Wednesday 3rd January 2024

RE: Deadline 2 Response, West Burton Solar Project

Comments on any submissions received by deadline 1

Appendix C: Hedgerow Removal Plans

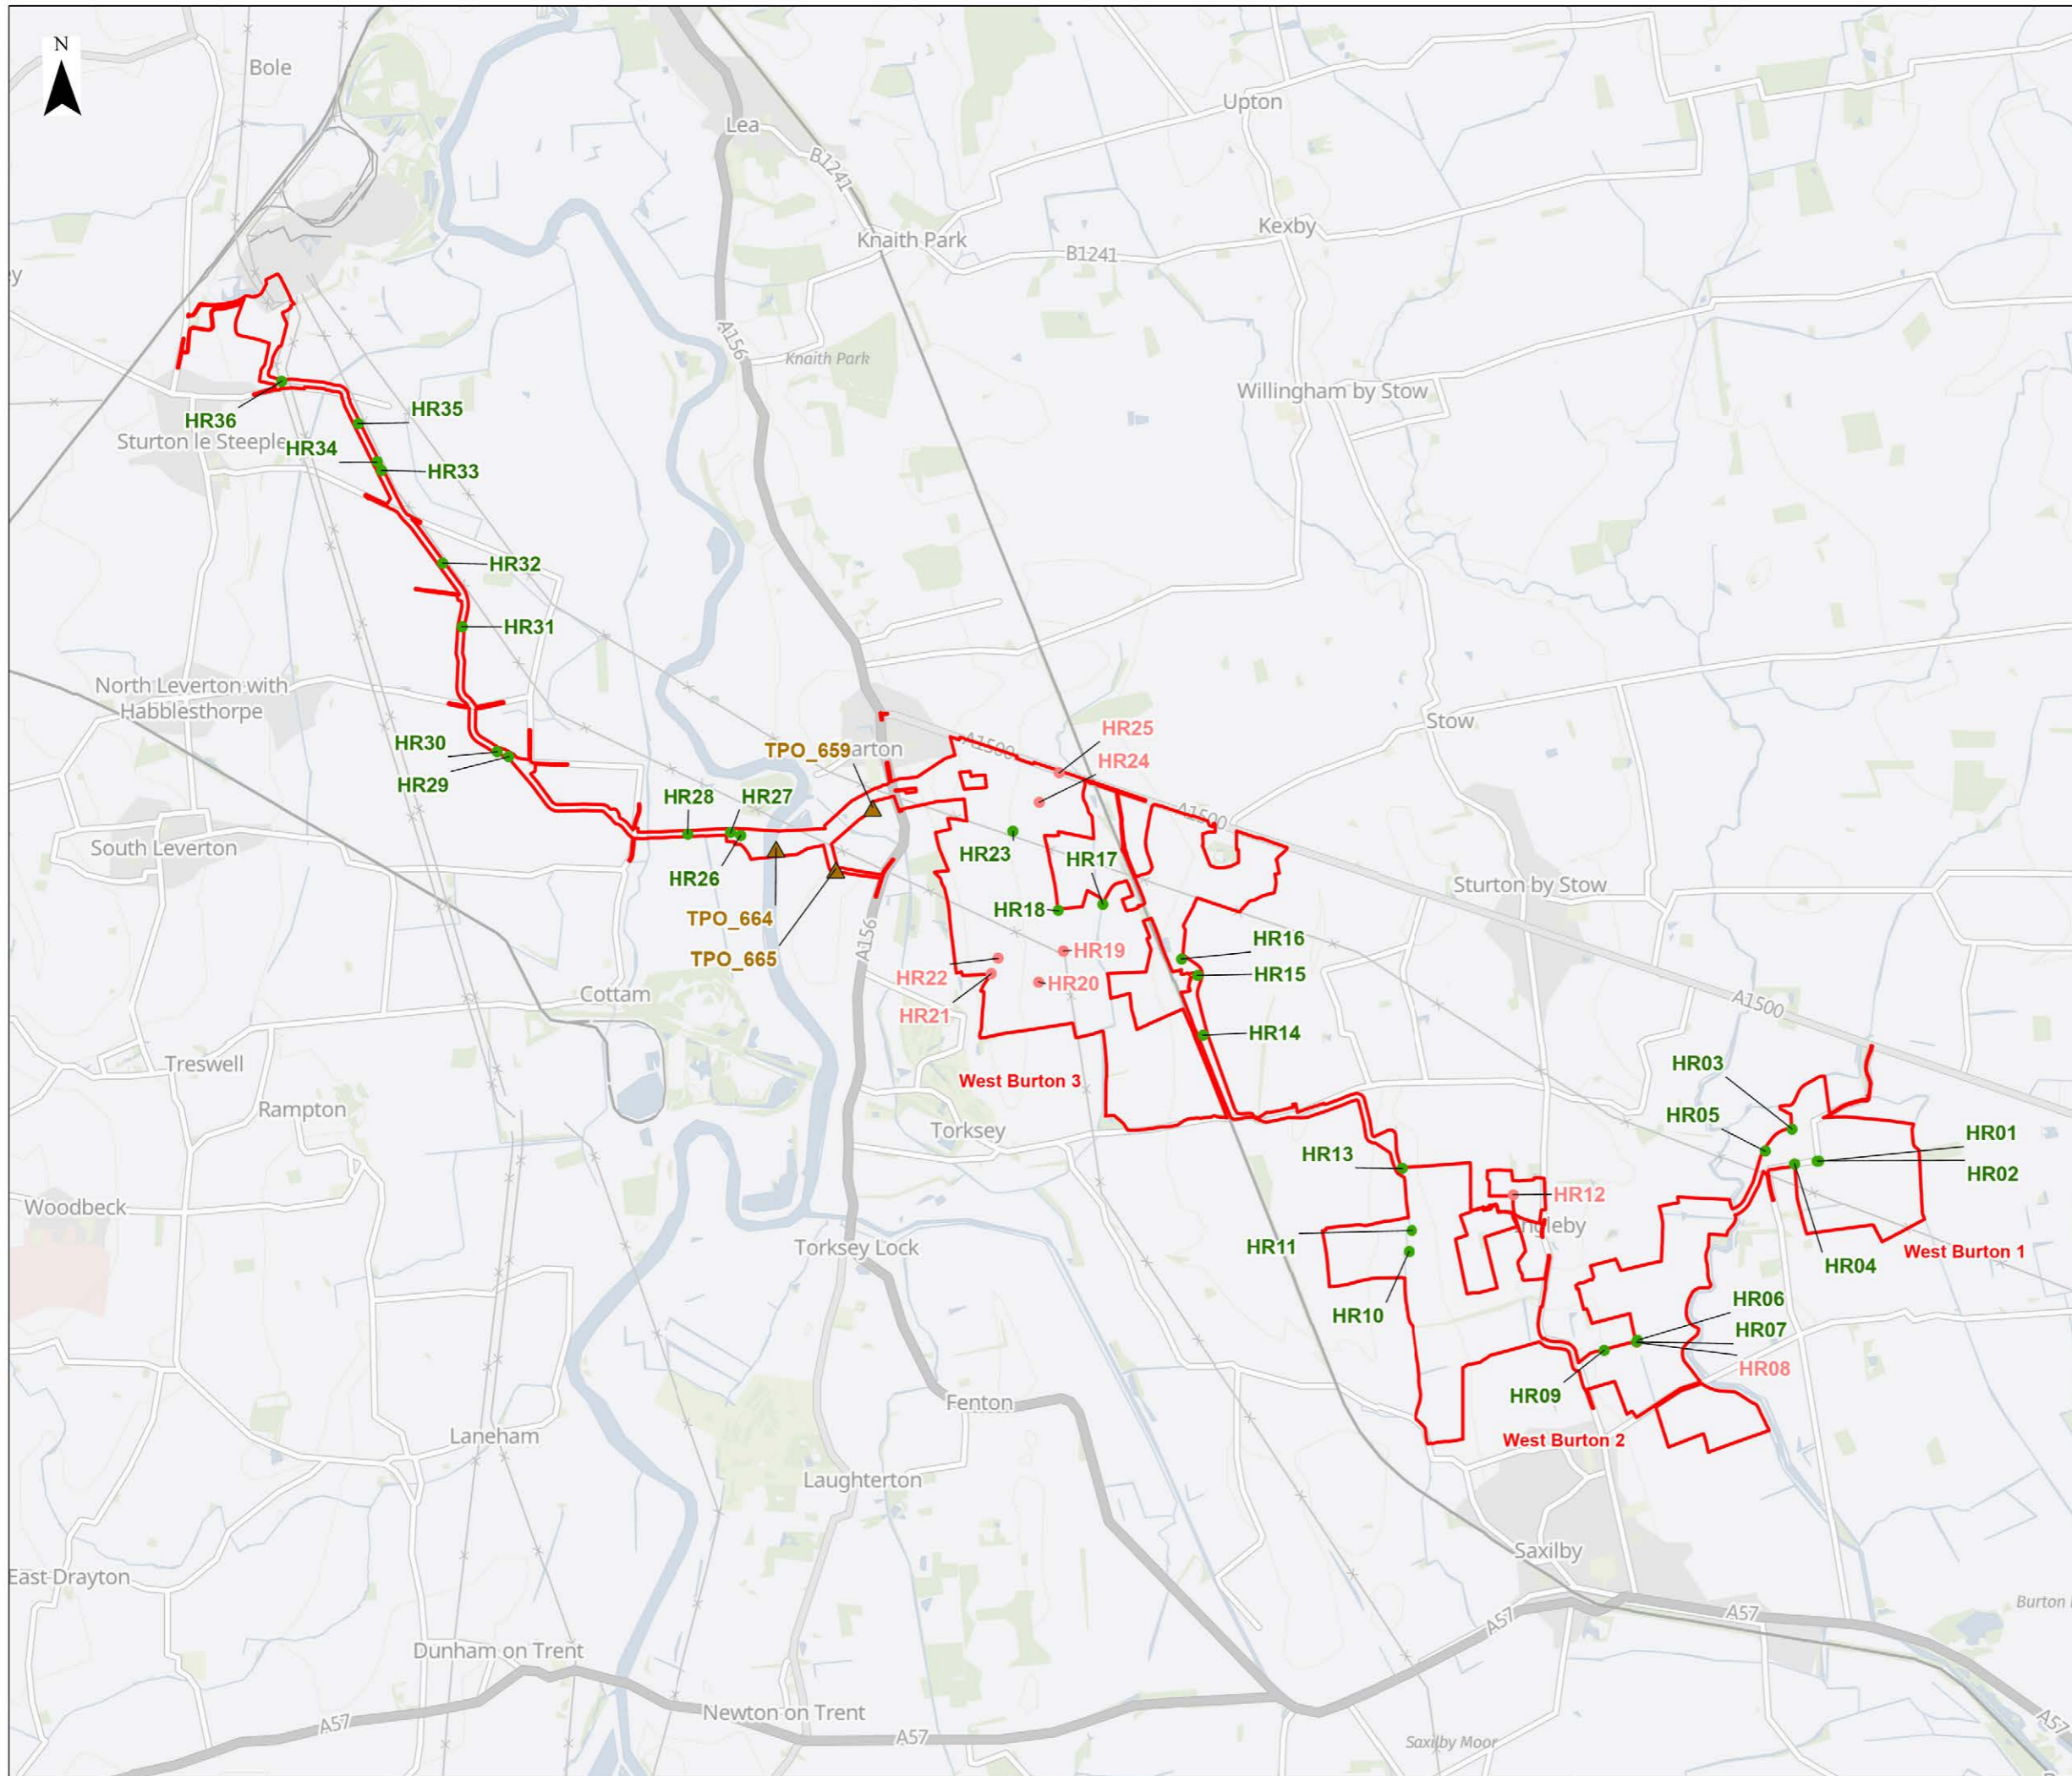
The Outline Landscape and Ecological Management Plan Revision A includes at page 59 a Hedgerow Removal Plan HR26. This shows that H146 and H147 respectively south and west of our dredging tip are proposed to be retained. We note that this plan also shows the temporary removal of a section of H148 to the southwest of our dredging tip and we await the Applicant's publication of a revised Crossing Schedule following further engineering consideration of the use of horizontal directional drilling of the cable routes in relation to our dredging tip and the adjacent flood bund.
